**Re: 4071.10 – The Asylum – Level III Development Review Application
Conditions of Approval**

On May 24, 2016, the City of Portland Planning Board granted site plan approval for the proposed Asylum project at 121 Center Street. To summarize, the applicant is proposing to demolish a portion of the existing 1-story building near the intersection of Center Street and Free Street and replace it with a larger 2-story building addition, construct a new 1-story building addition off Lancaster Lane and construct related site improvements. The Planning Board approved the application with a number of conditions (see below). Enclosed are updated approval drawings that address these conditions.

DATE OF RECORD:	JSK
DRAWN BY:	TAR
SCALE:	NO SCALE
PROJECT No.:	4071.10
SHEET No.:	C503

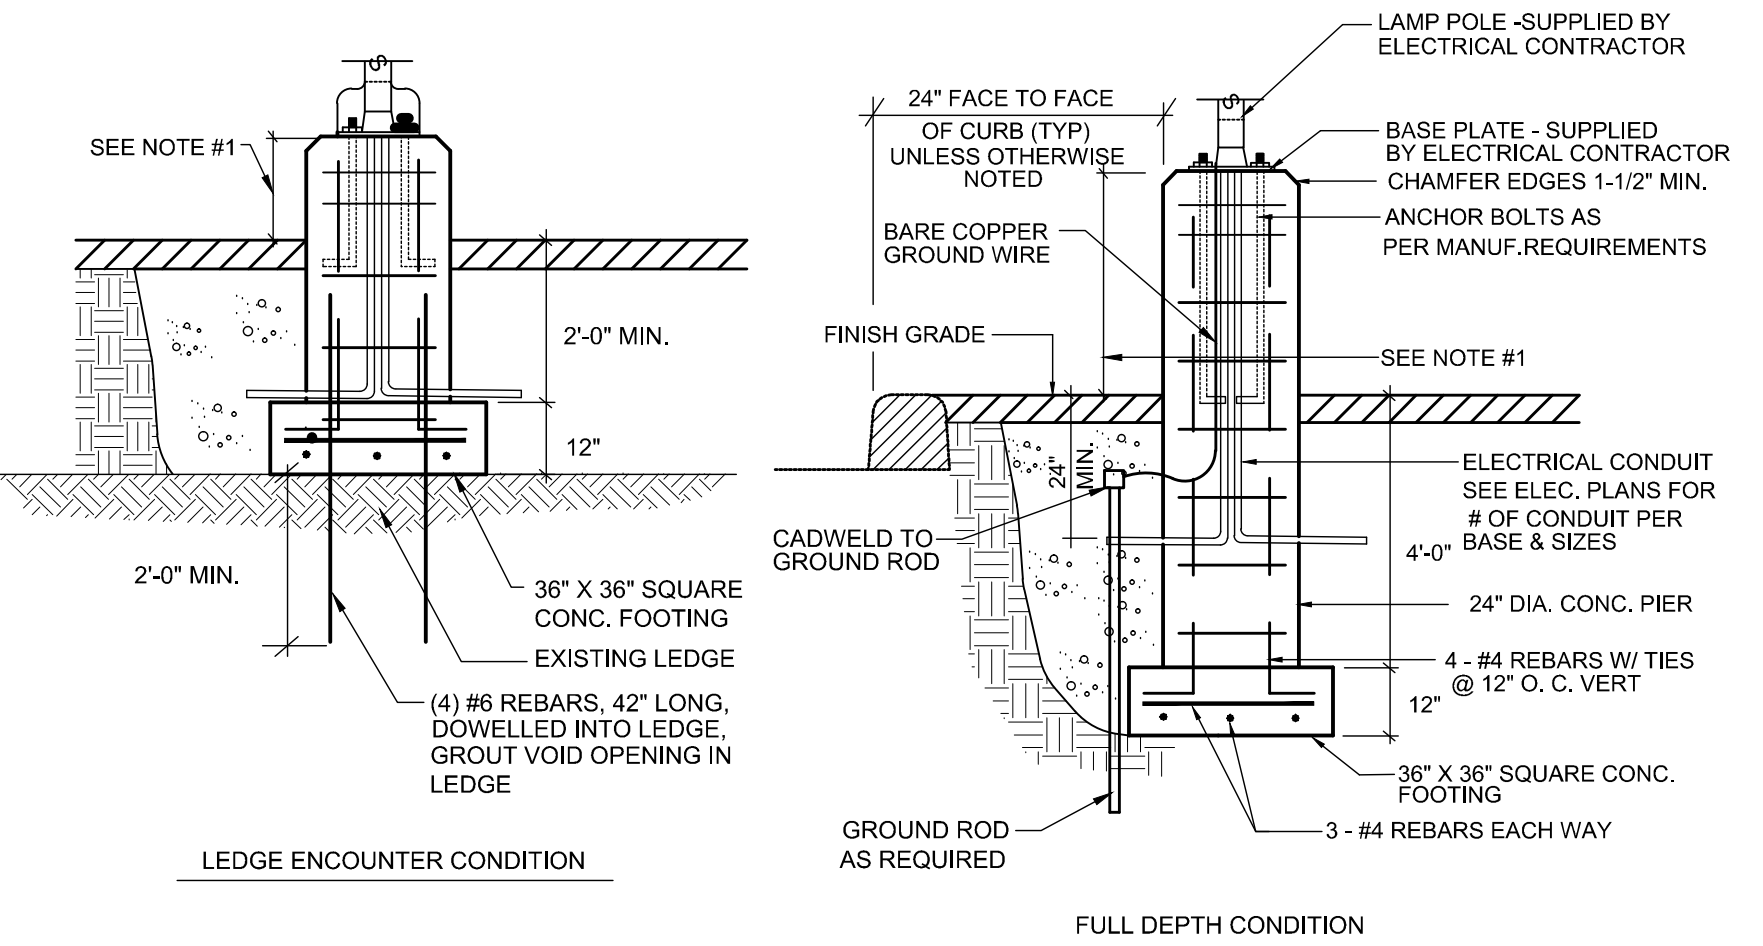
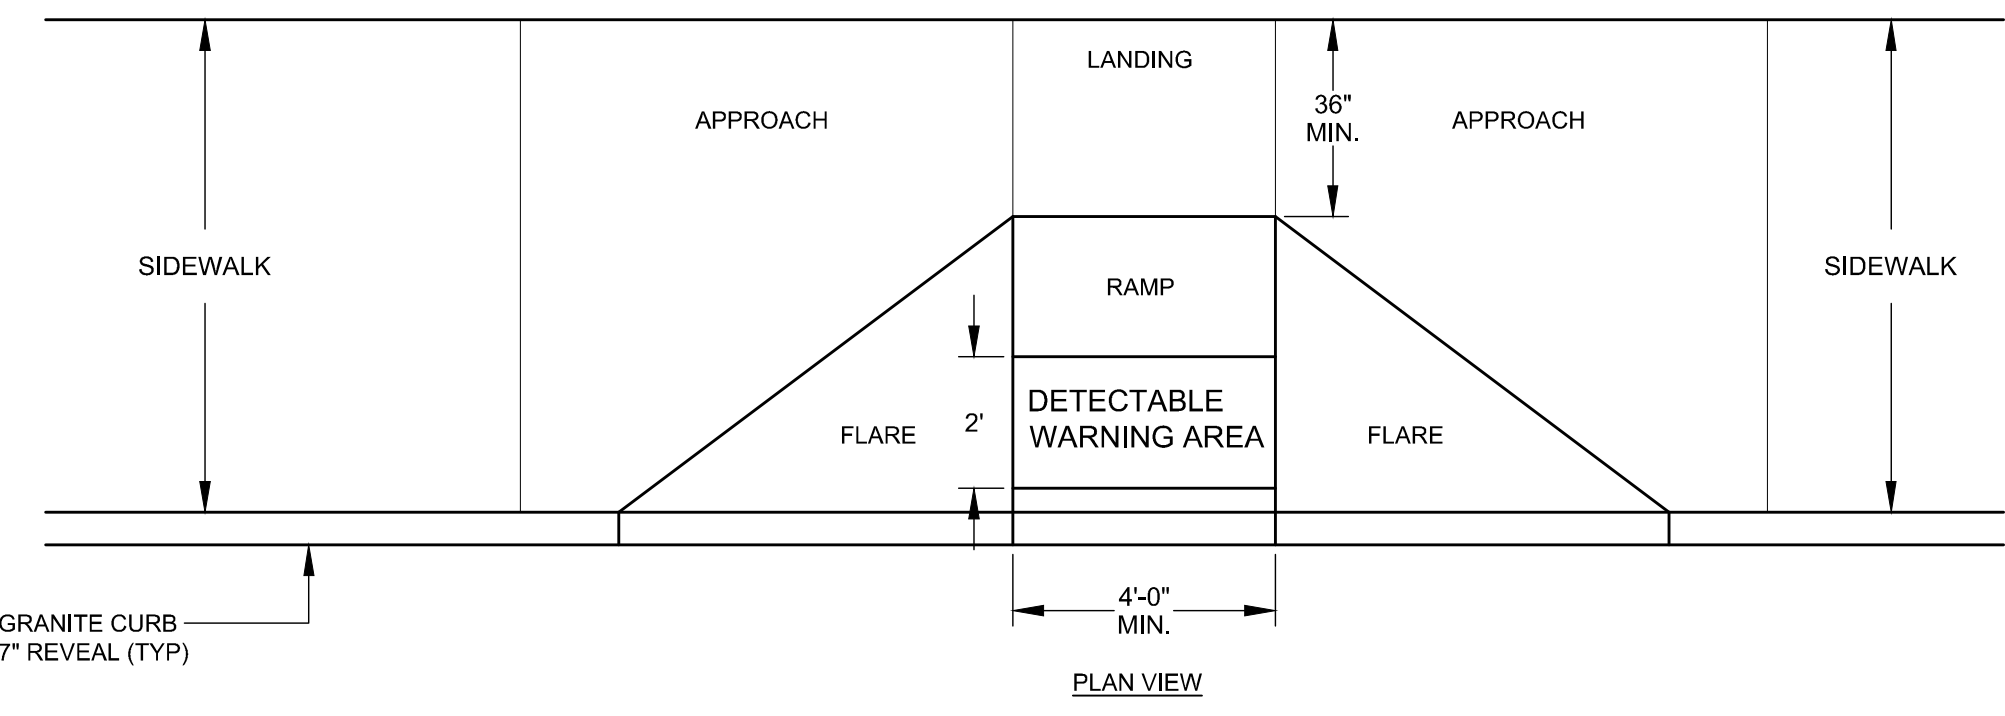
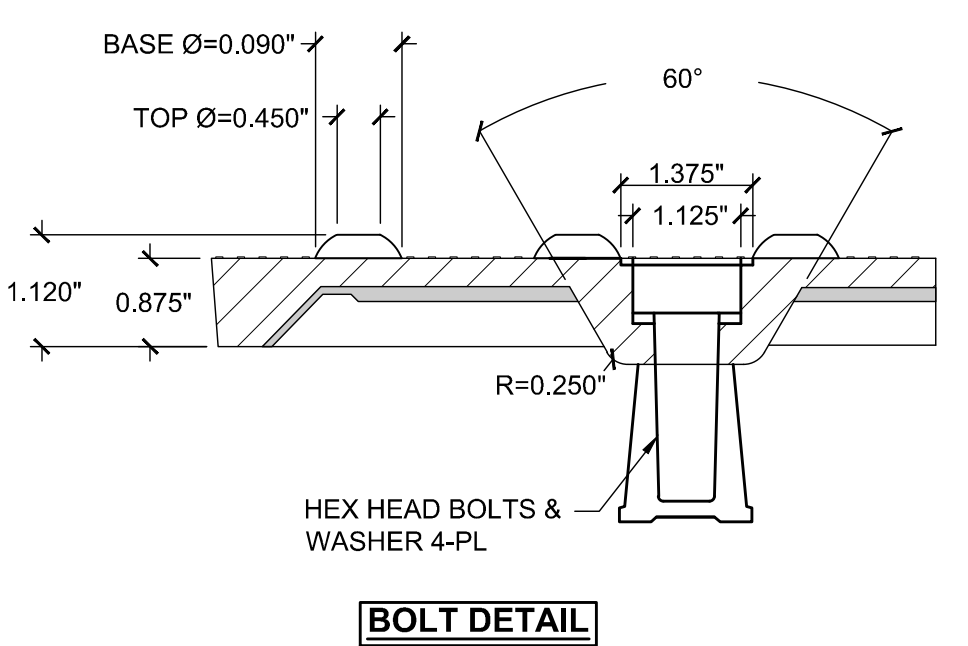
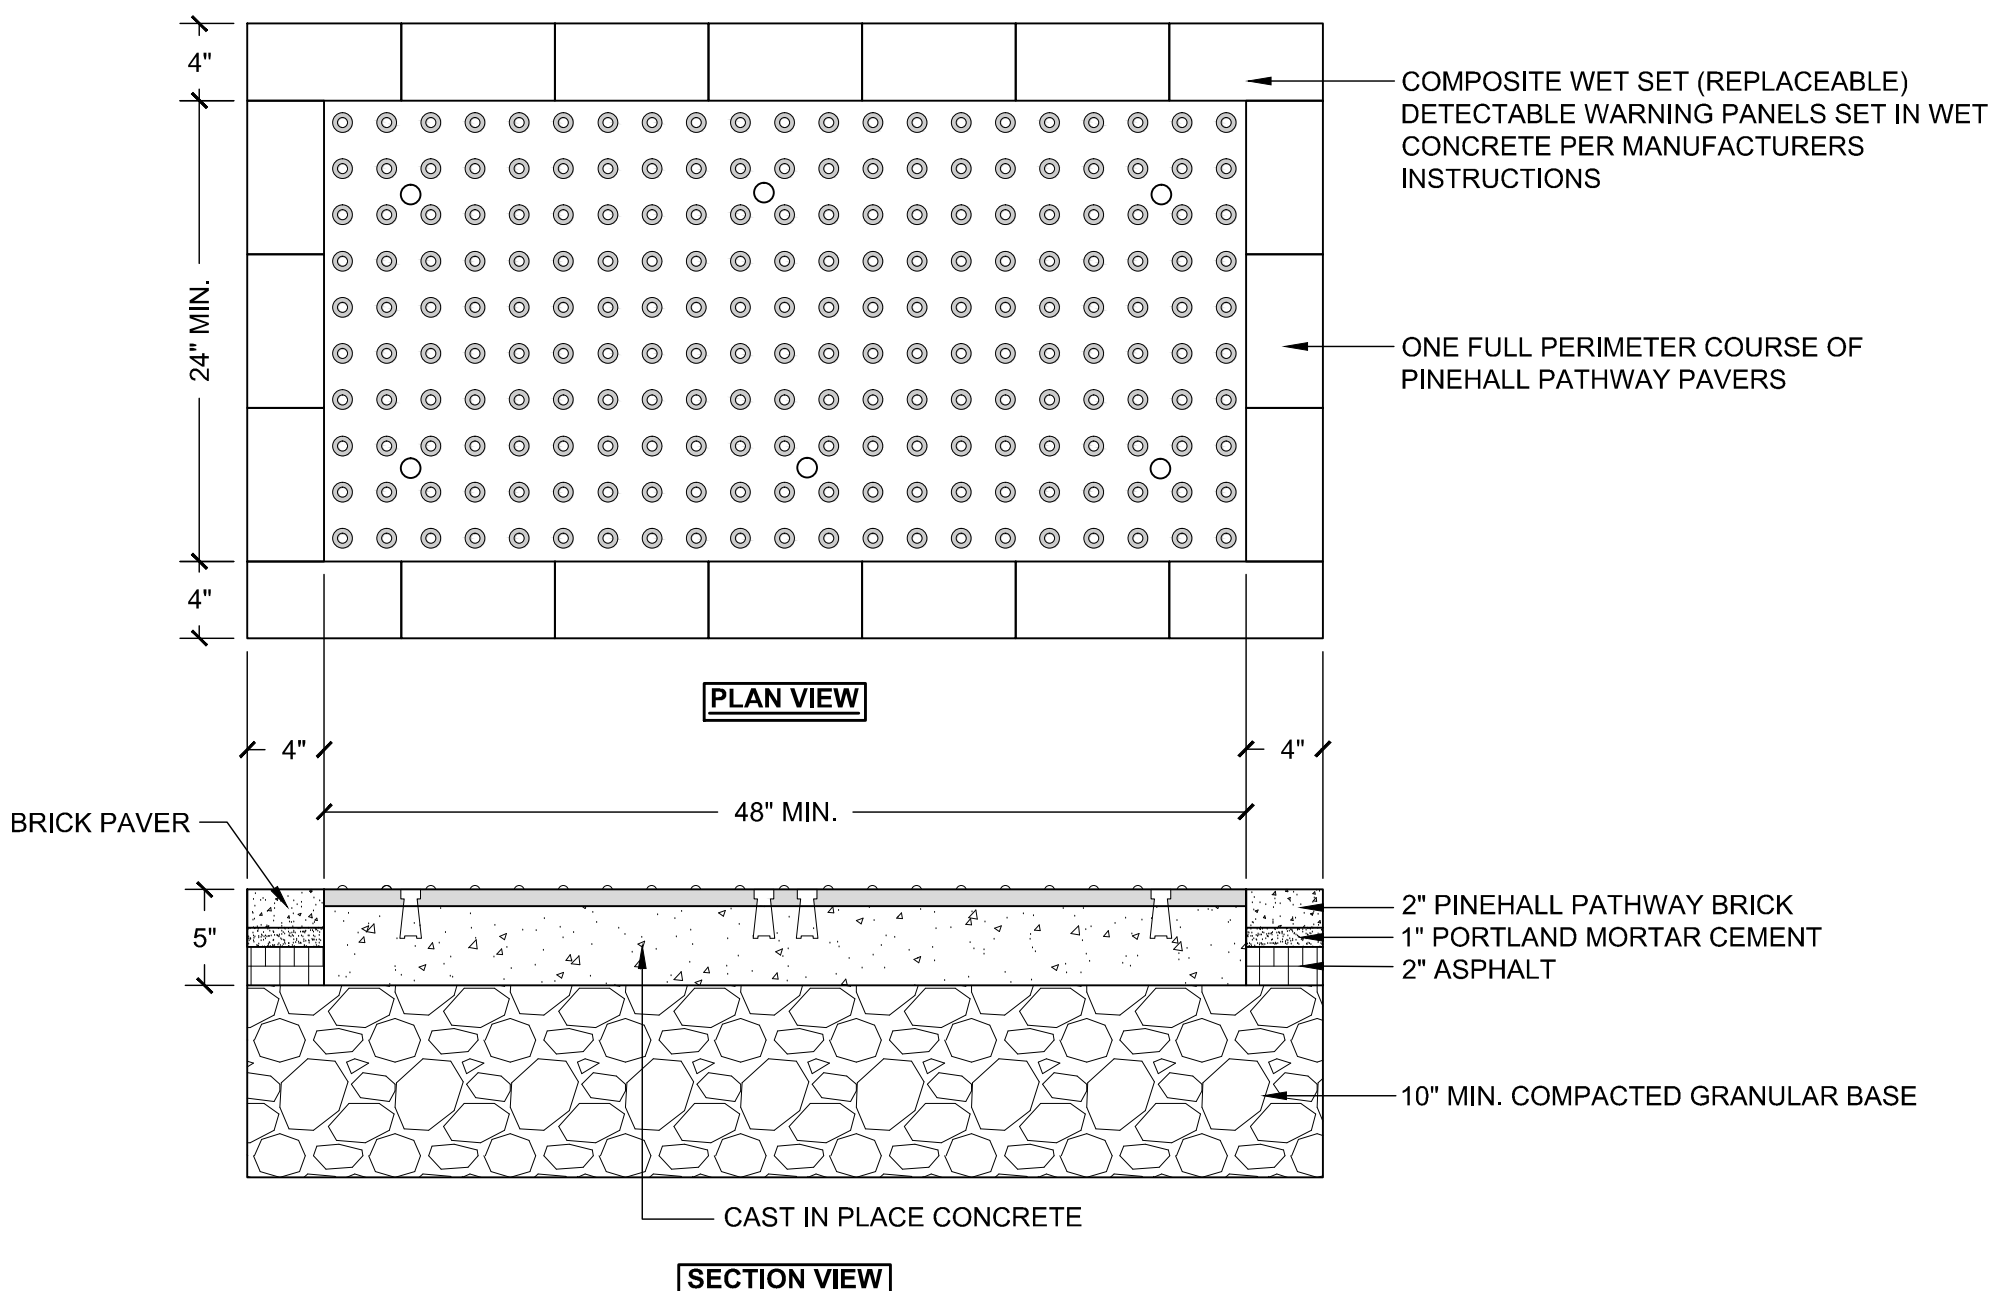
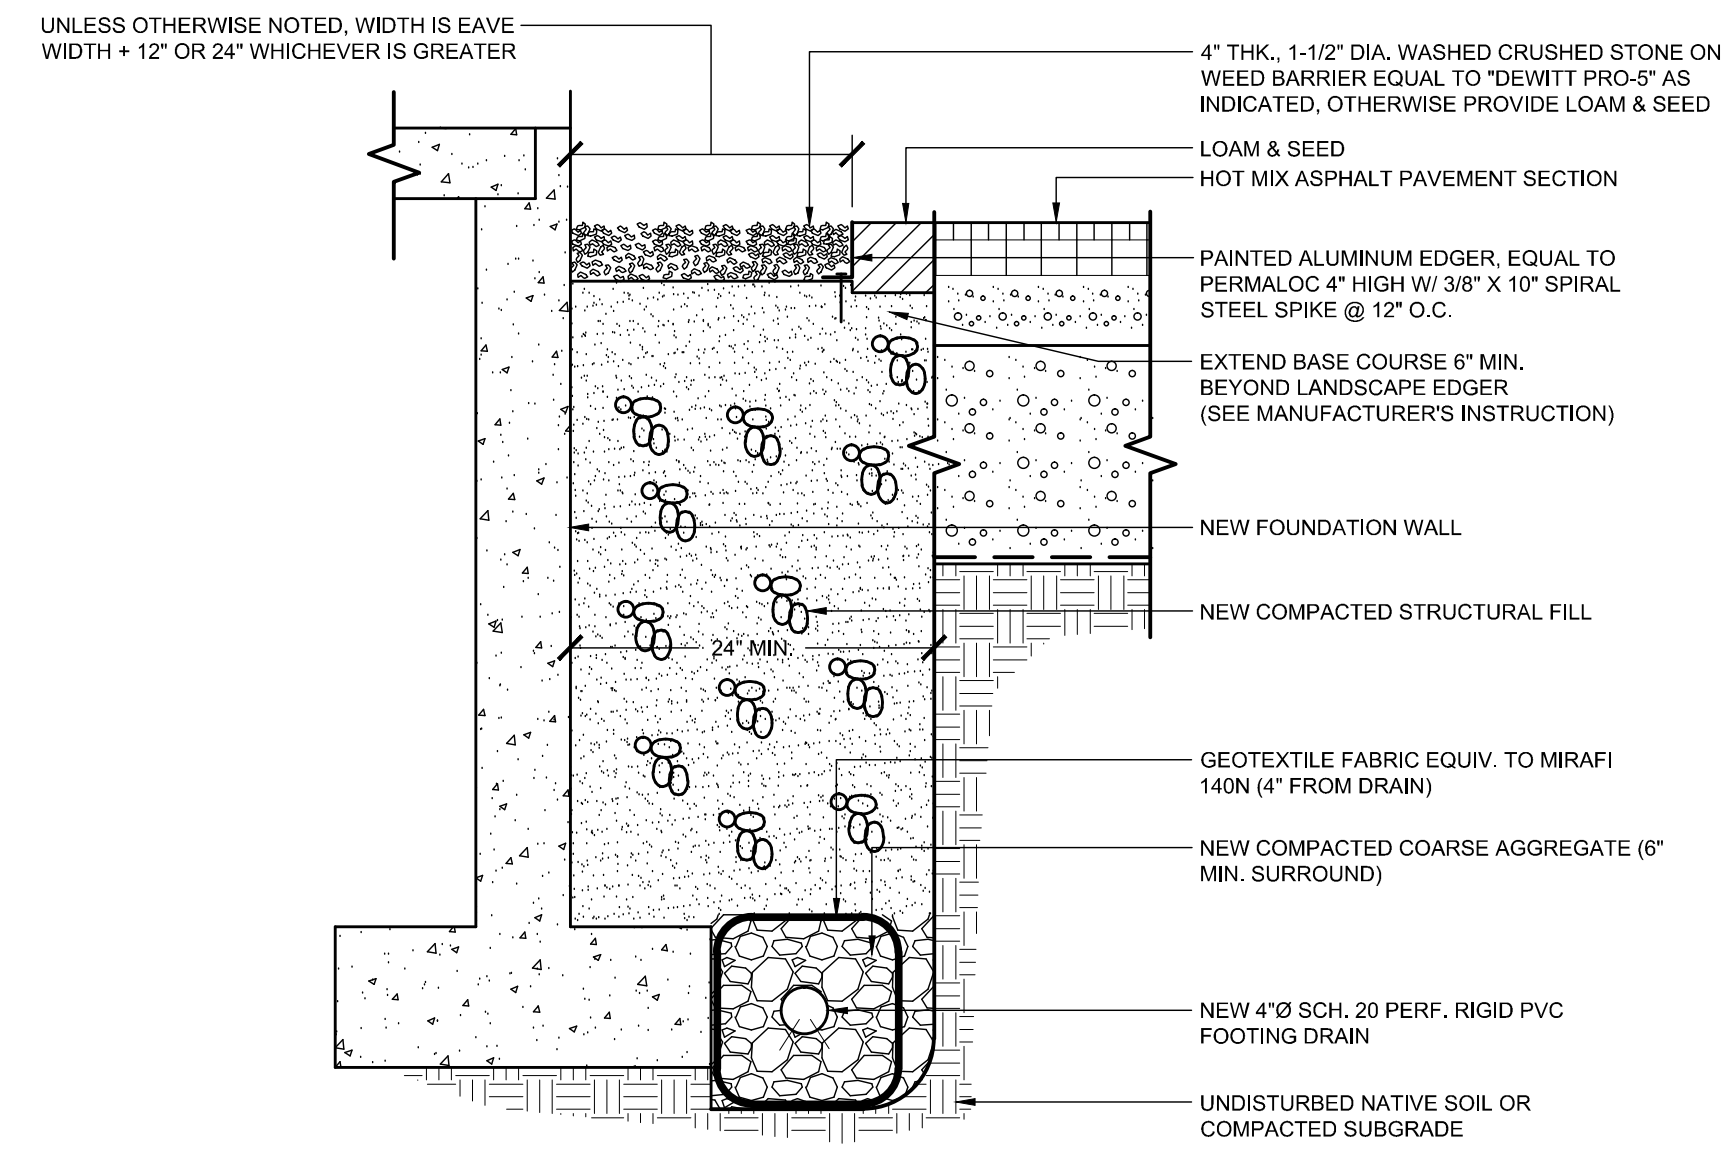
7. Sheet C503 shows a detail of an interior manhole drop connection. These connection are not allowed in city owned and maintained manholes. **Manhole is no longer shown.**
